Please ask for: Nicola Moore
Email: nicola.moore@arun.gov.uk
Telephone: Ext 37944
Our Ref: BR/122/20/OUT
Your Ref:
Date: 31st July 2020

Application for Outline Planning Permission

Development: demolition of garth house and west view to be replaced with 20 self contained apartments
Location: Garth House High Street Bognor Regis PO21 1HQ

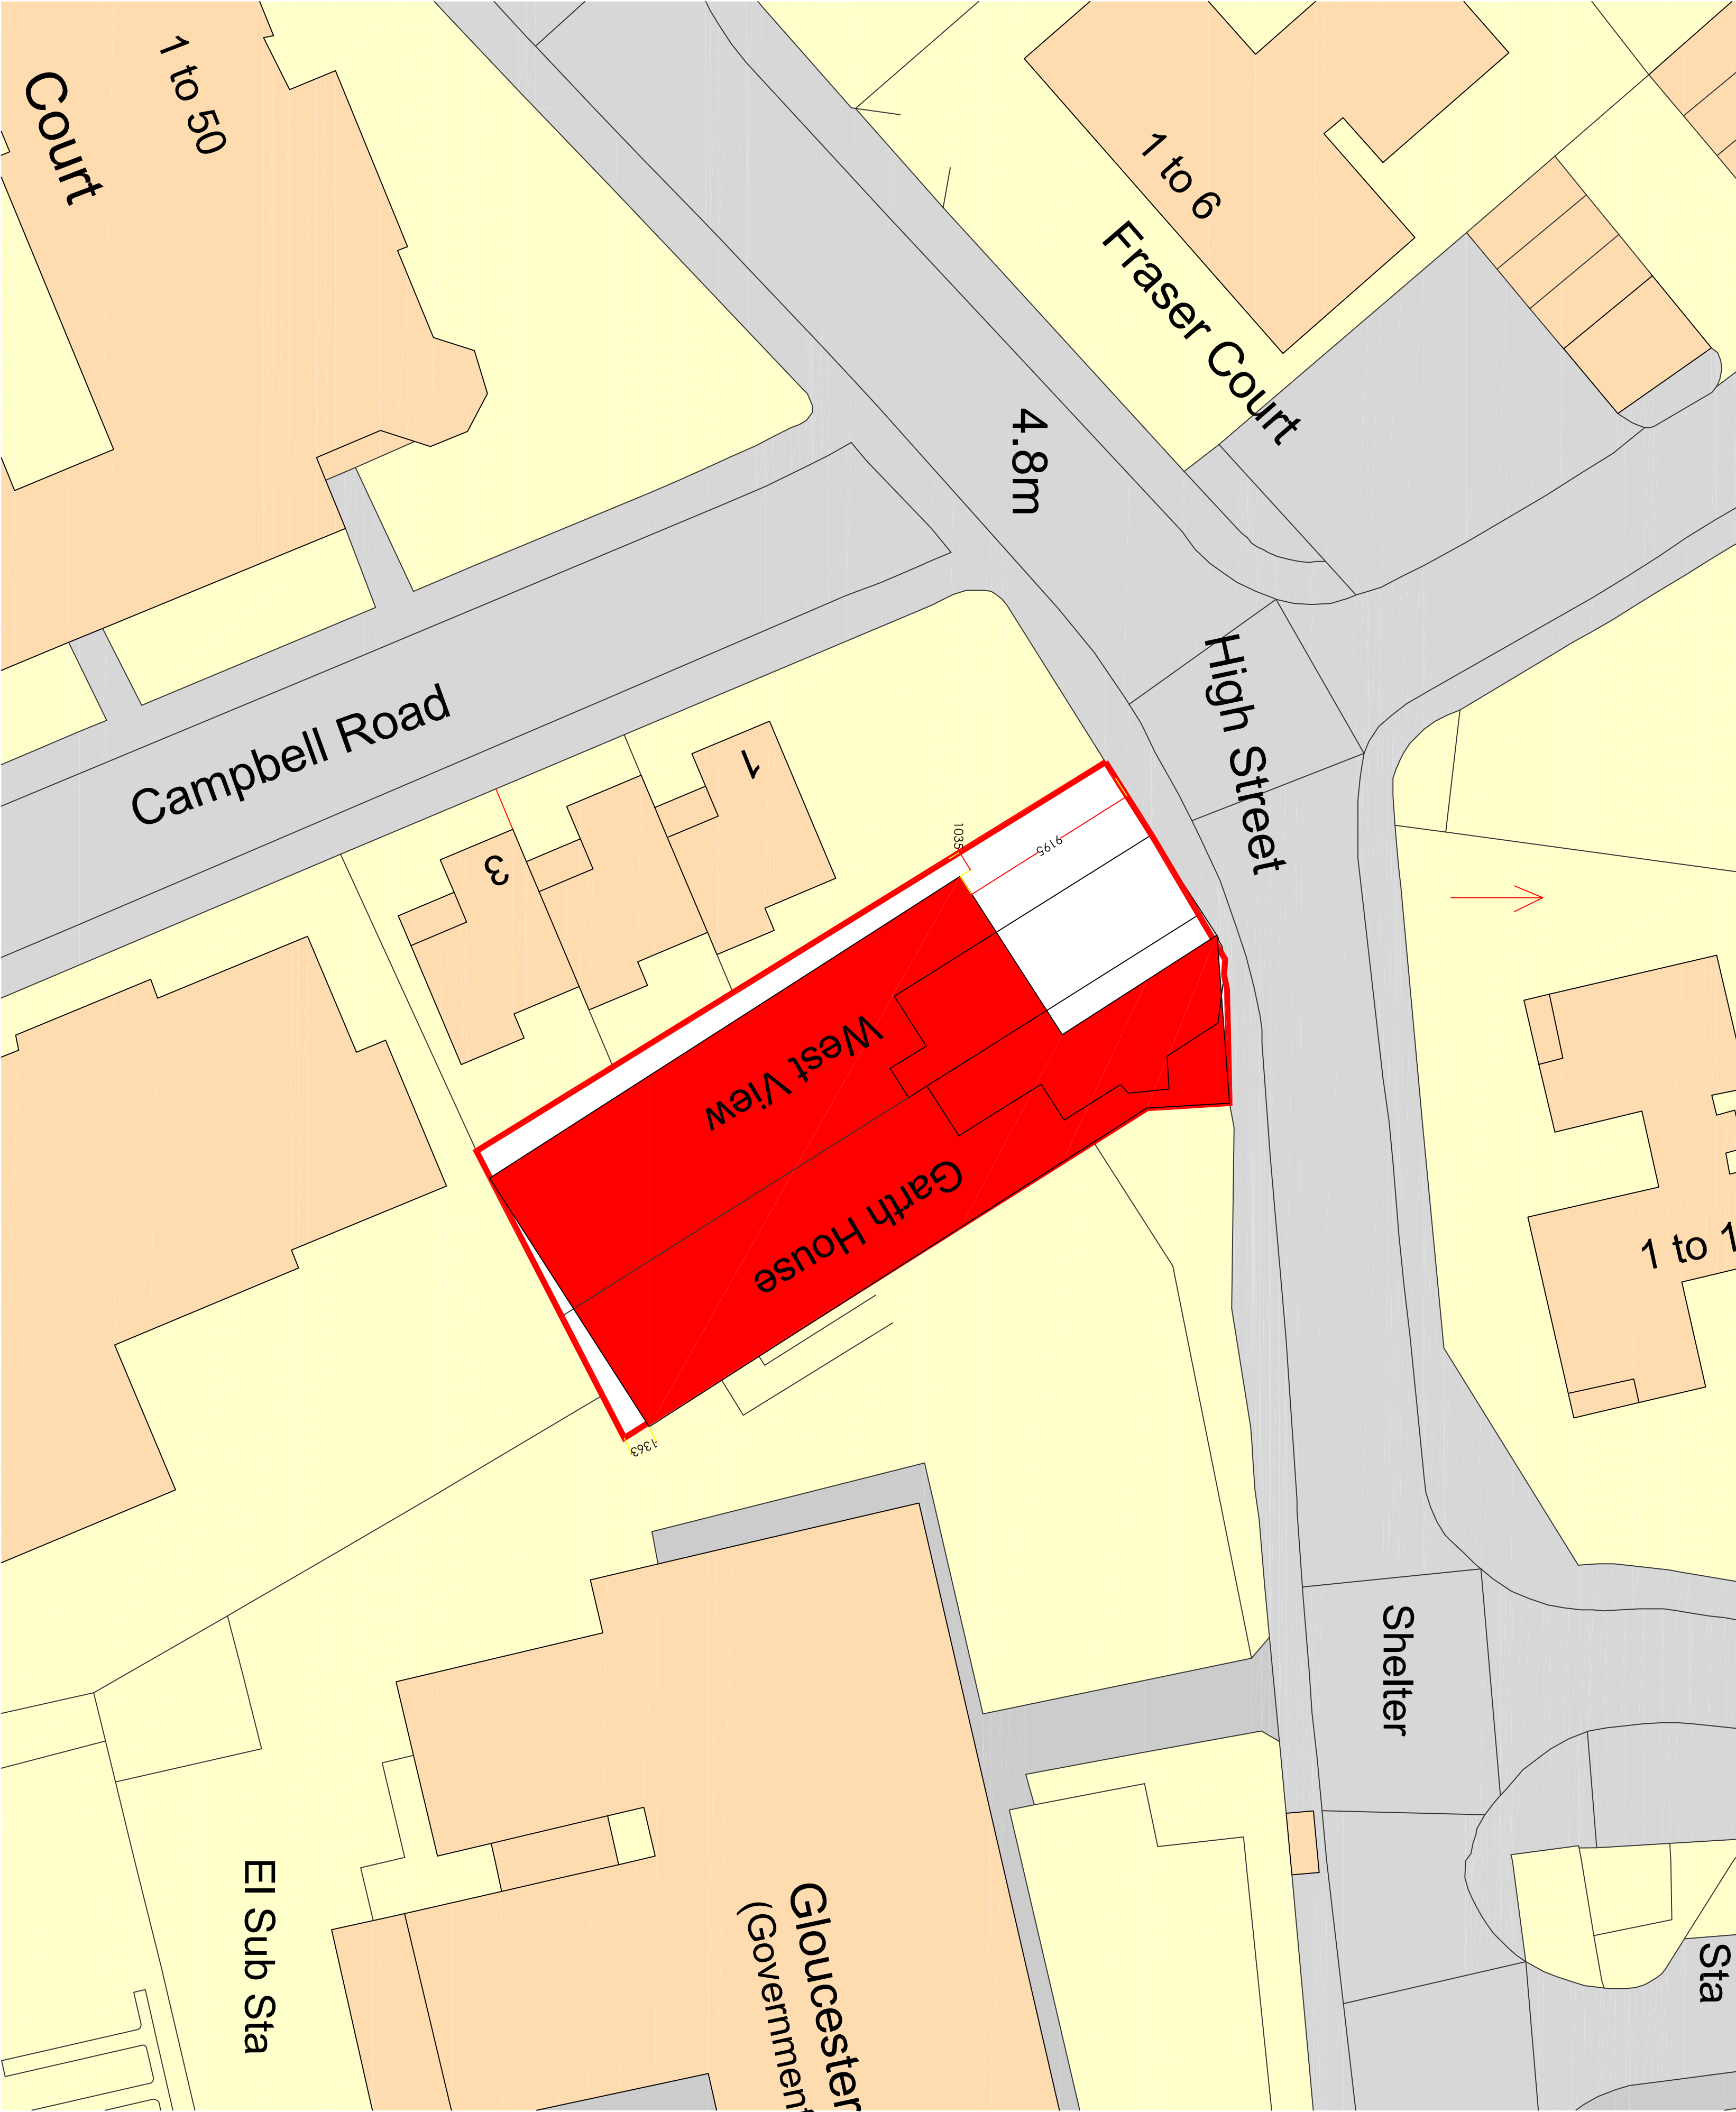
Block Plan

The Block plan should also include the footprint of the demolished building/s and all measurements to boundaries of the proposed development. Please submit at a scale of 1:500 or 1:200
